**Submission - SSD-13166280 Blind Creek Solar Farm - EIS Public Exhibition –  
Council Ref: PR.2022.1018**

Thank you for the opportunity to provide comments on the EIS for the Blind Creek Solar Farm Project at Bungendore. Council's comments are as follows.

DRAWN: CT  
DATE: 12.04.2022  
SCALE: 1:750 @ A3  
DWG NO: 167-S02A

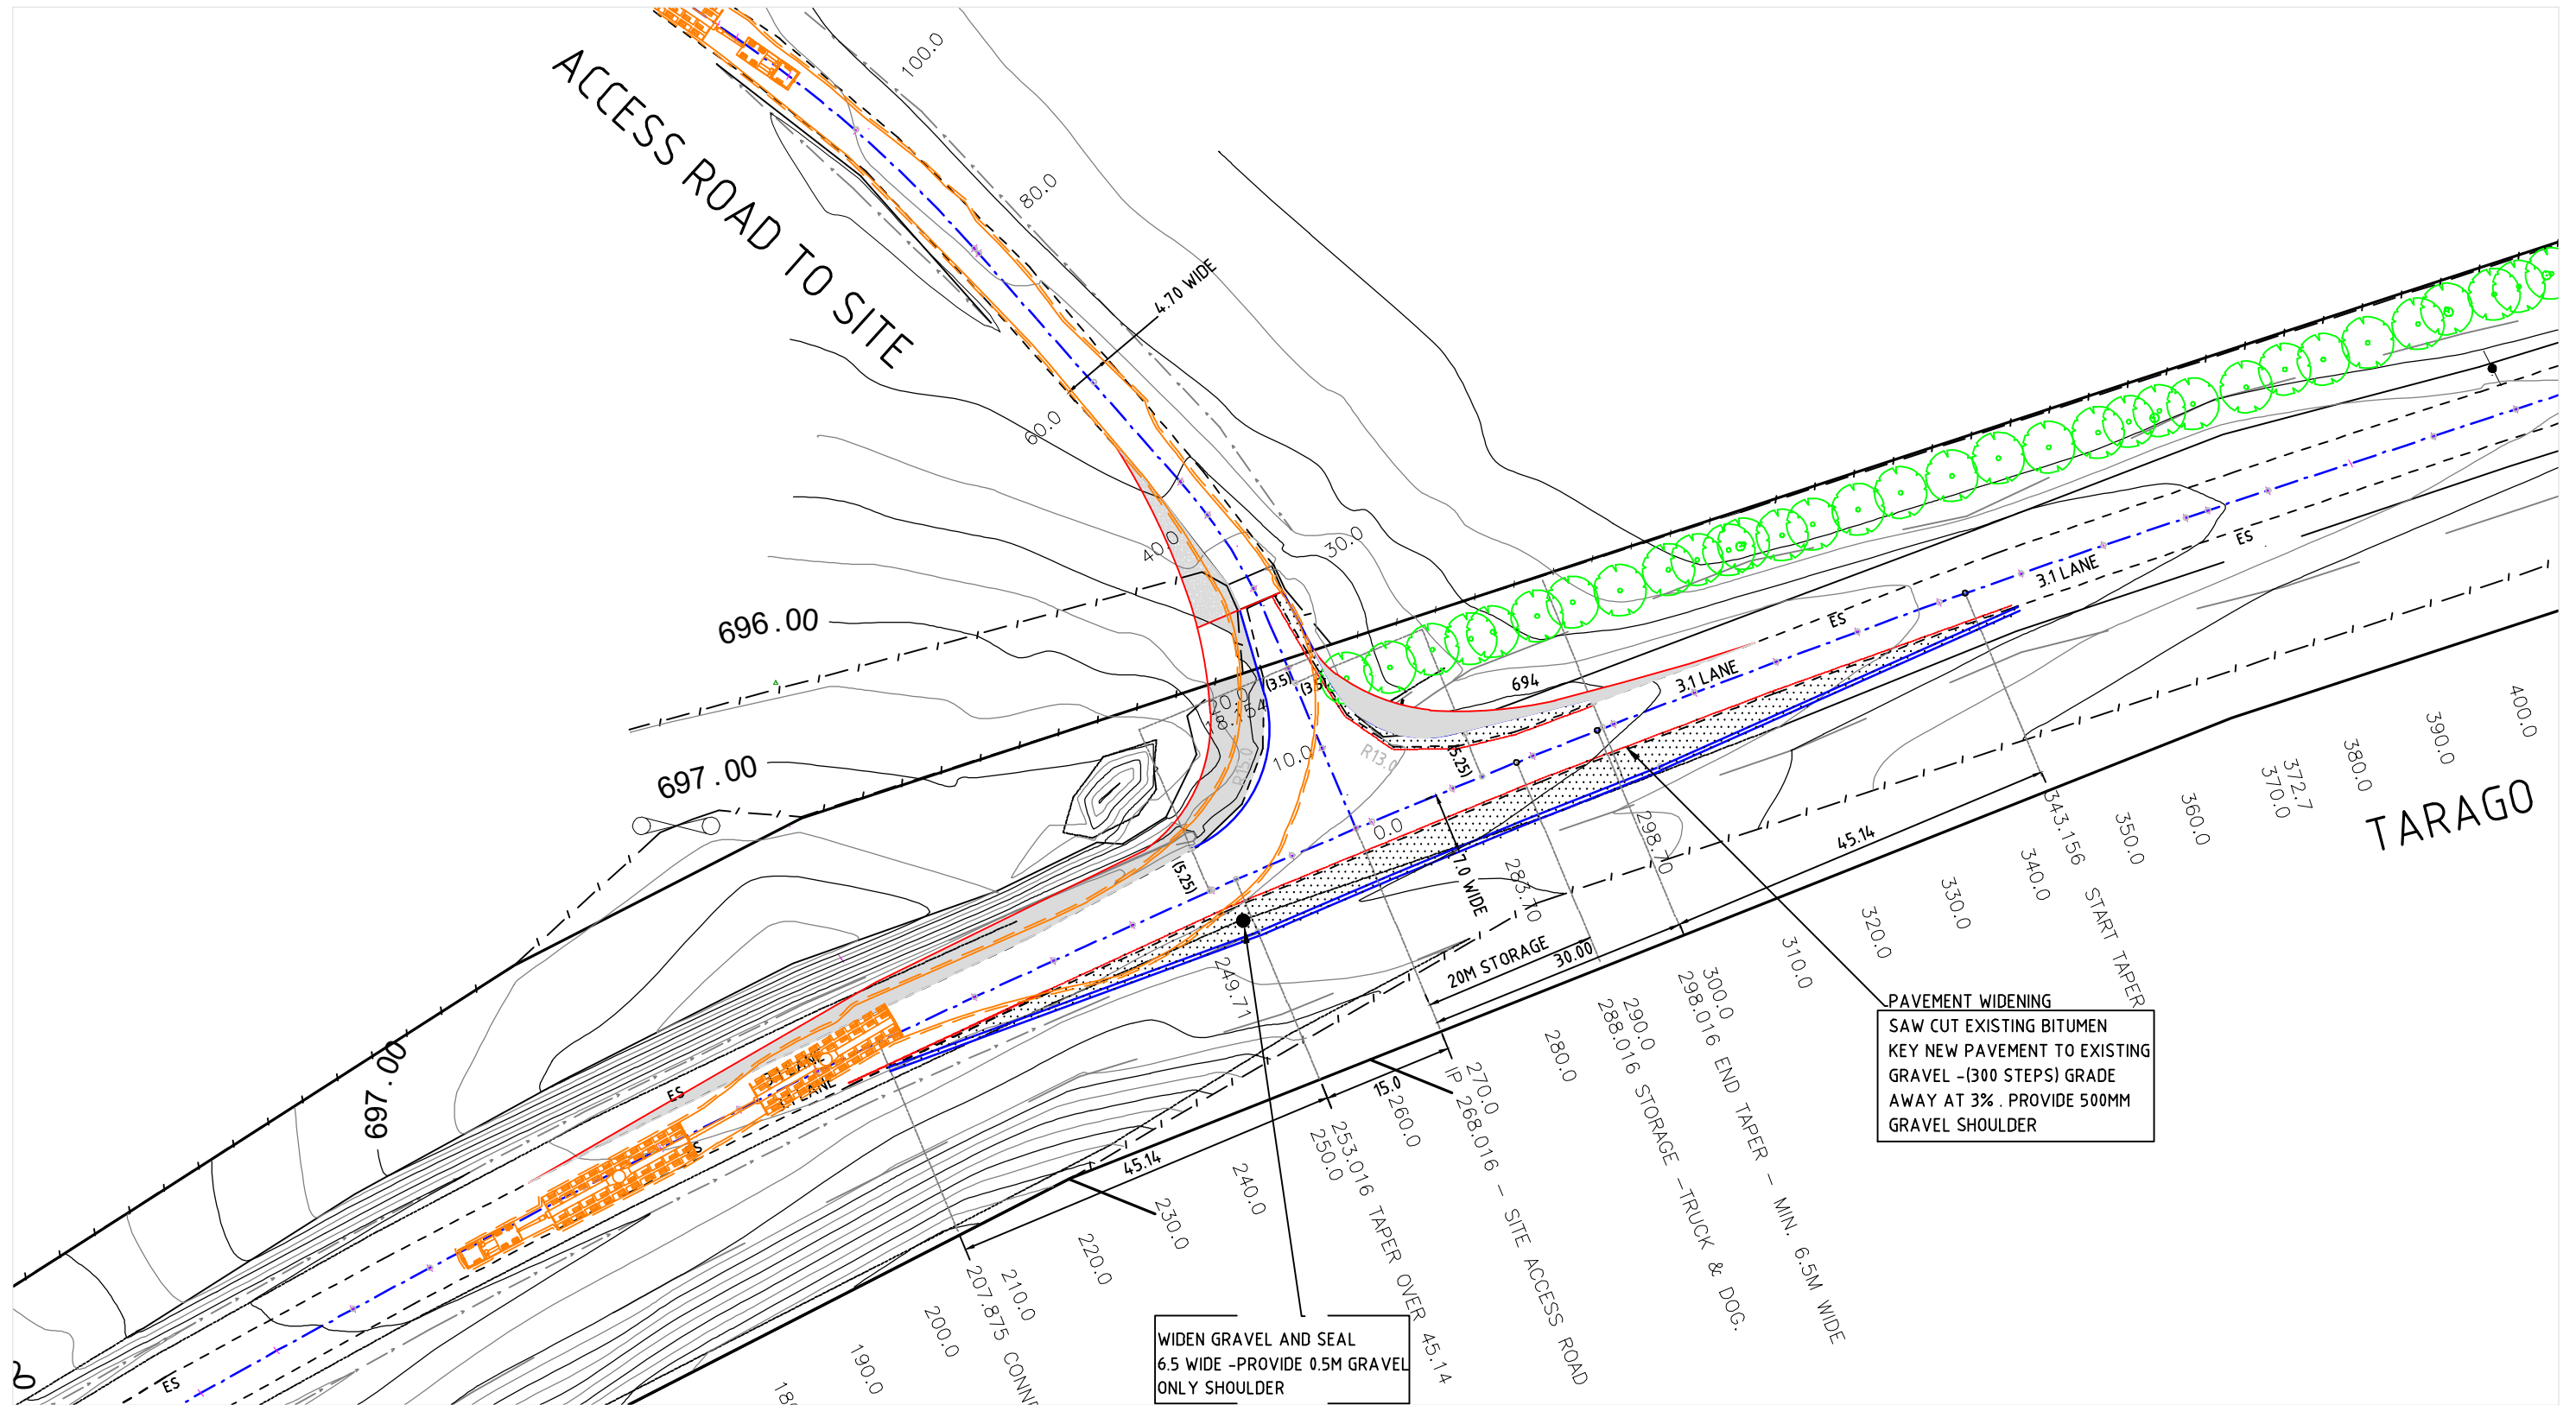
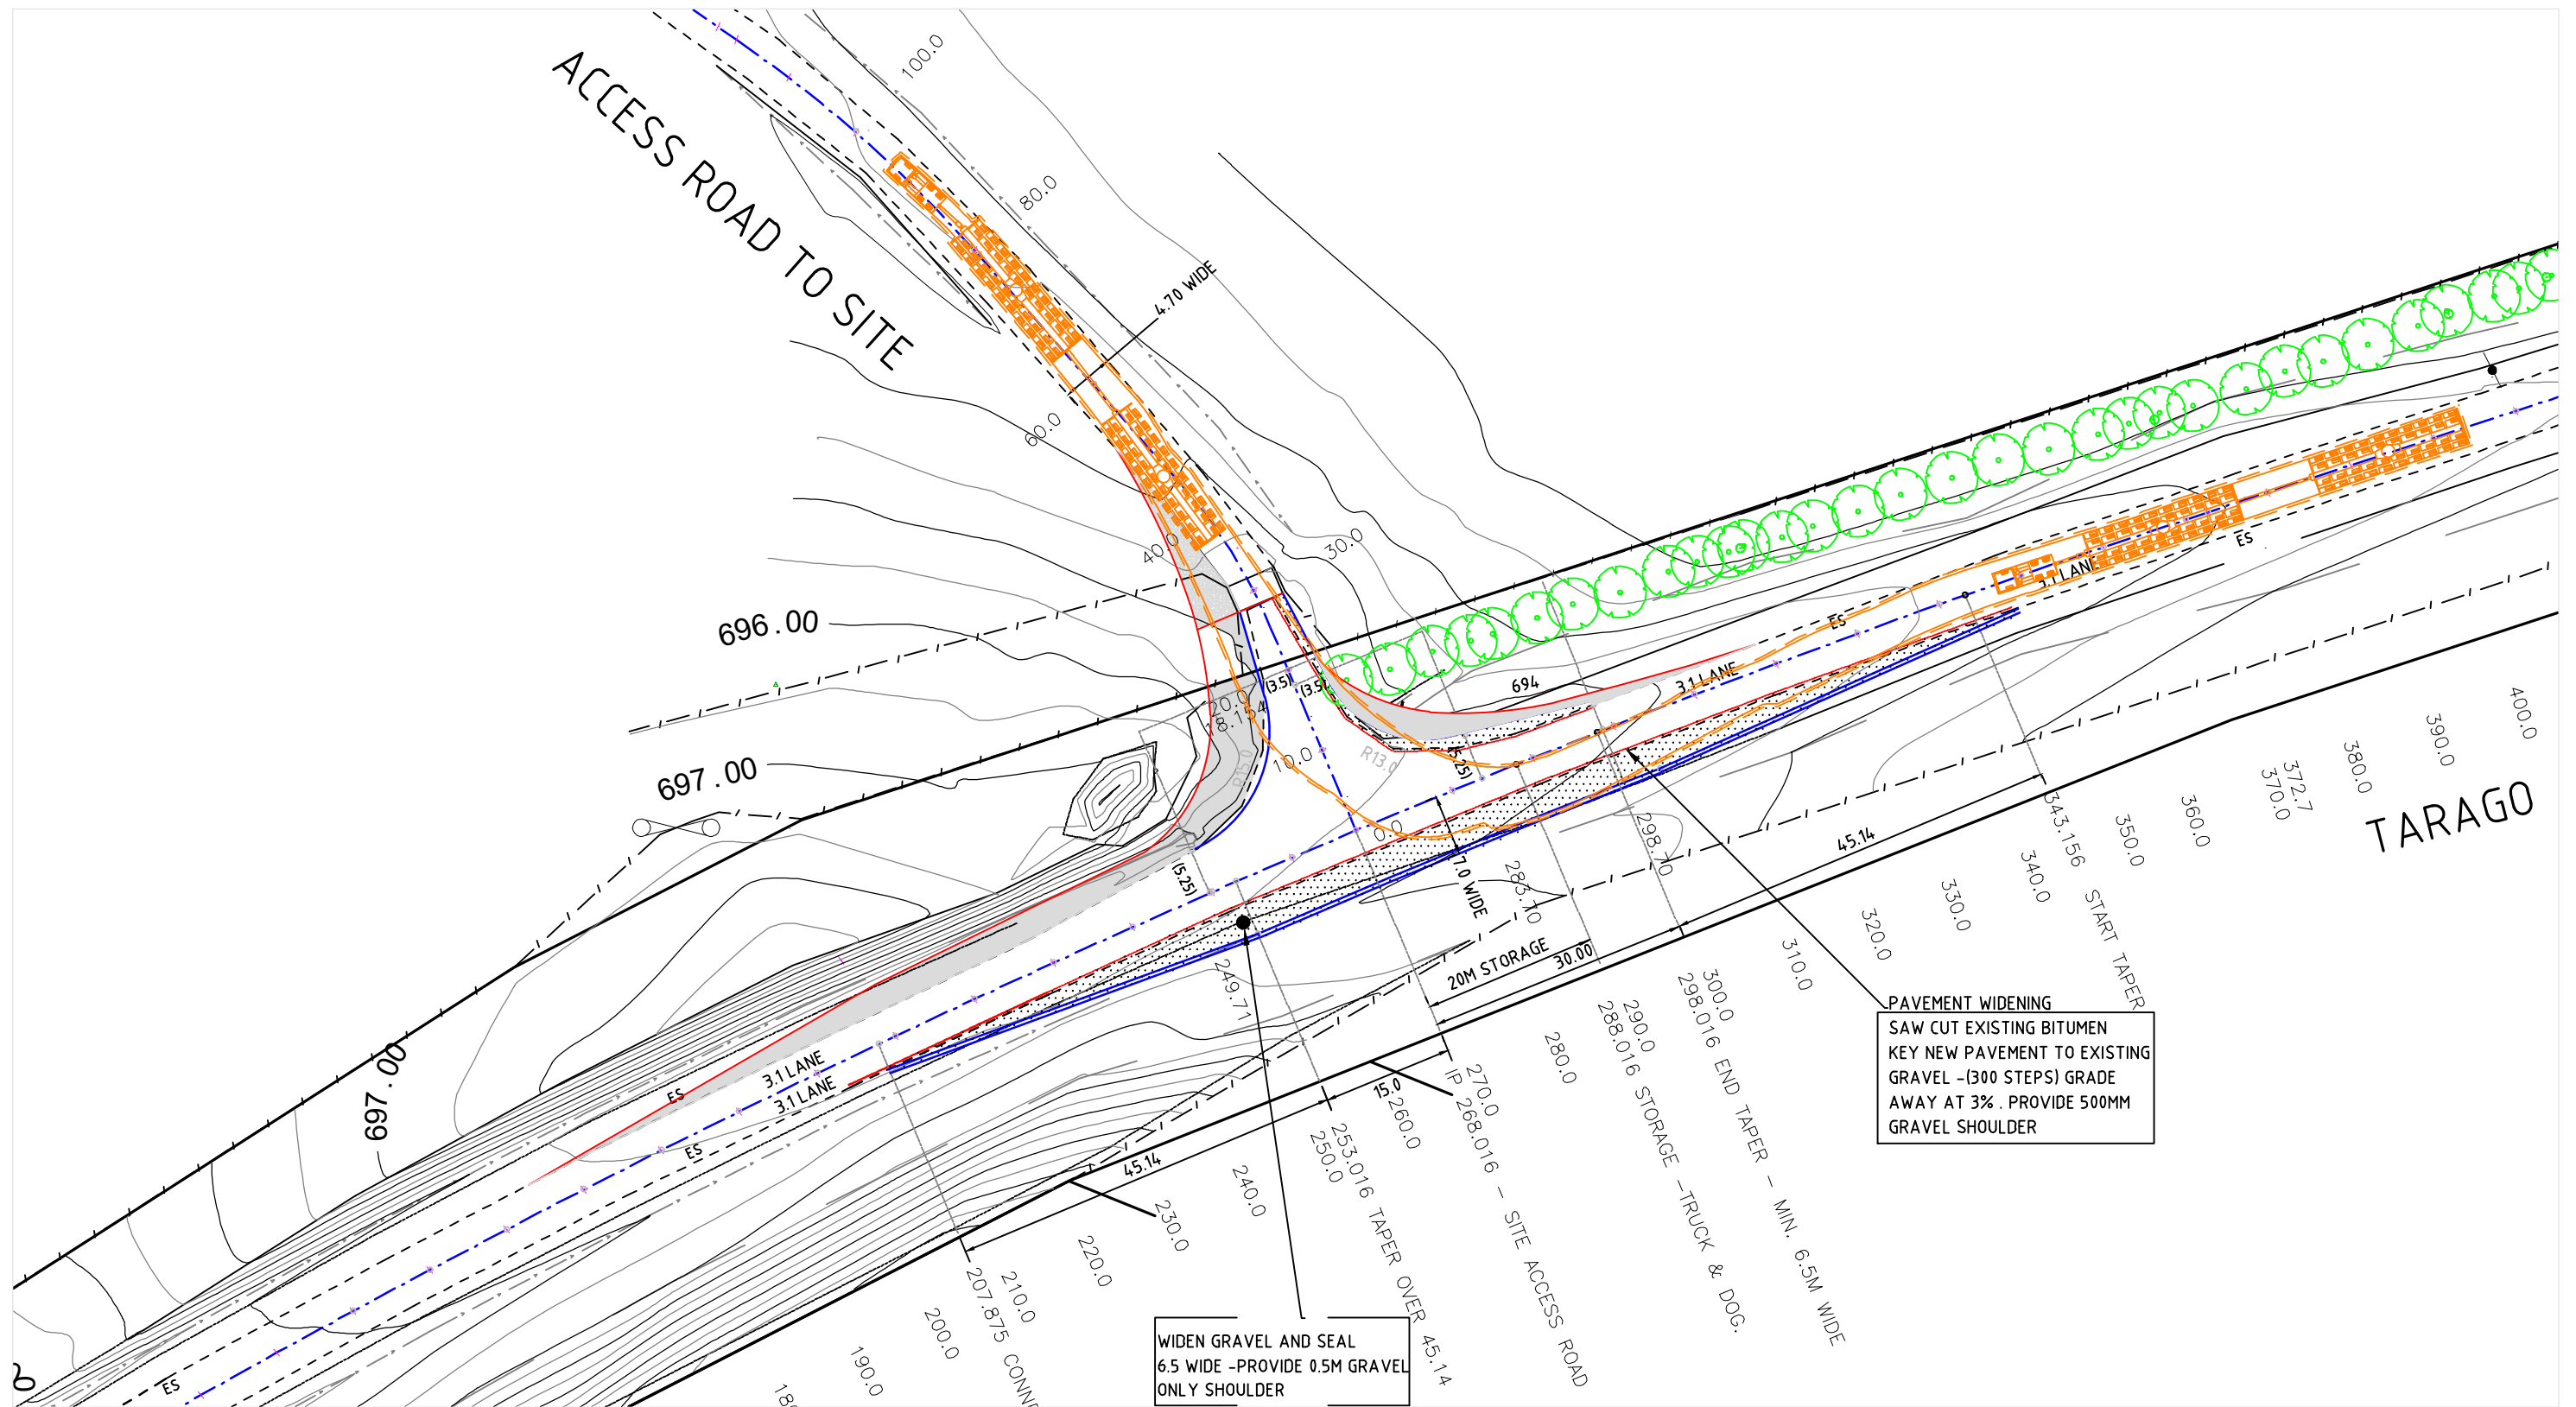
4. The OSOM (Over-size / Over-mass) vehicle described in the swept path assessment appears to be a vehicle that will require a police escort as part of any approval to operate on the subject road network.
5. The traffic impact assessment is generally constrained to Tarago Road without sufficient consideration and assessment of the impact on other nearby roads.
6. The assessment does not address financial reparations for damage to the road caused by the increased construction traffic associated with the development.
